**RE: LHM Jeep
Grading and Drainage Plan (Stamp Date 3-31-2016)
Hydrology File: K19D023**

RE: LHM Jeep Parking- K19D023
Comments March 04, 2016

Comments on 1-27-16 submittal:

CO.1

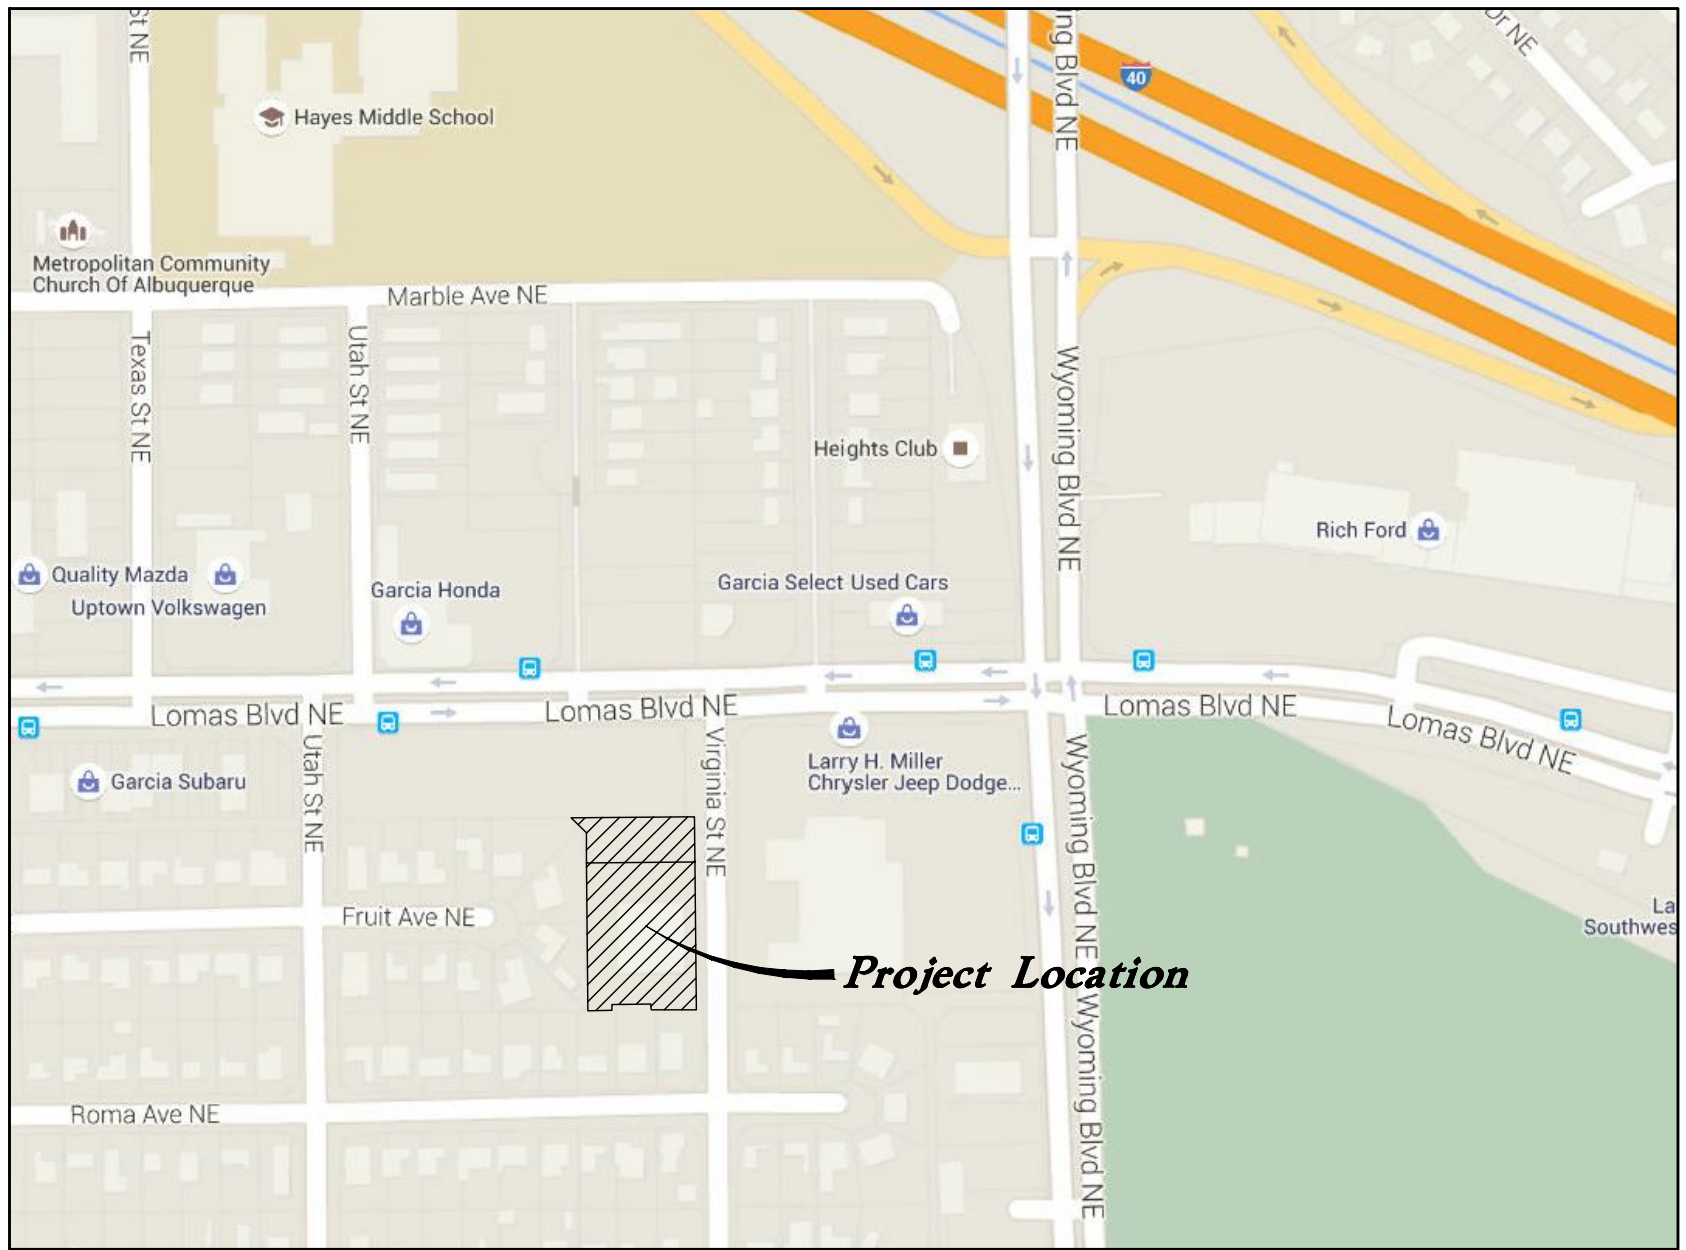
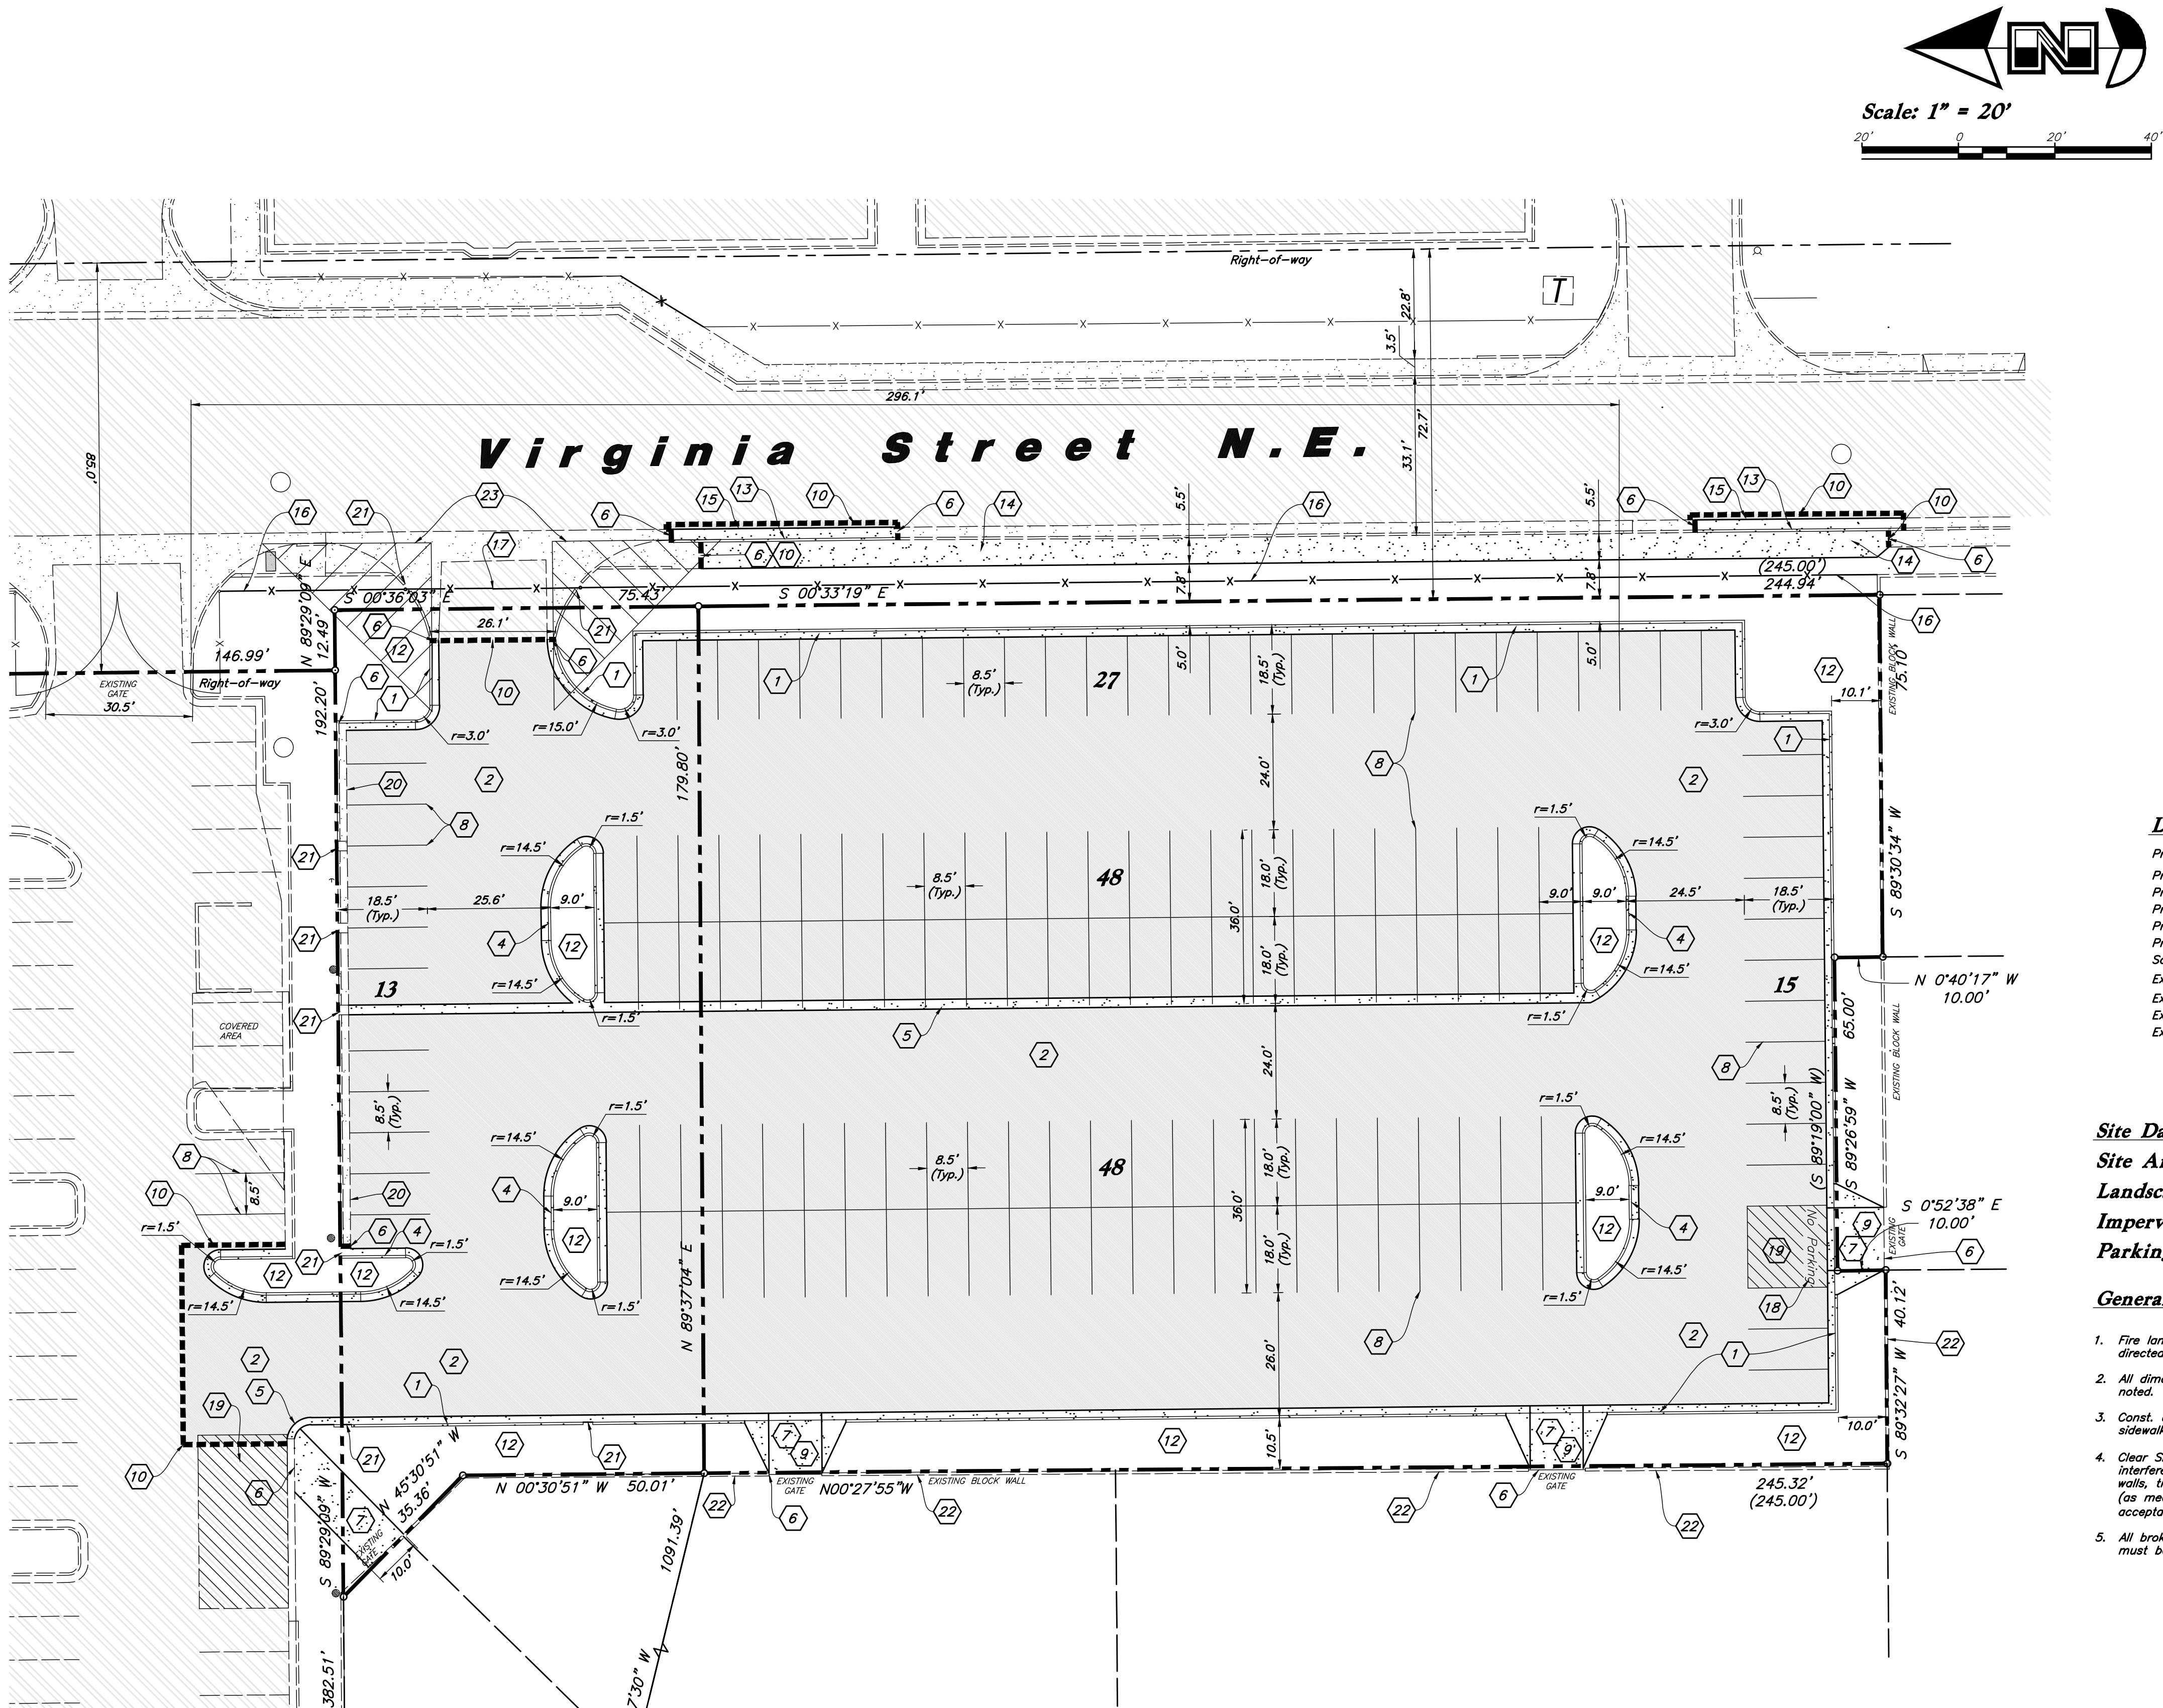
Comment: Add a general note to replace curb and sidewalk stones to nearest joint.

Response: Note added, Sheet C0.1, Demolition Plan, General Demolition Note 18: Replace curb and sidewalk stones to the nearest joint.
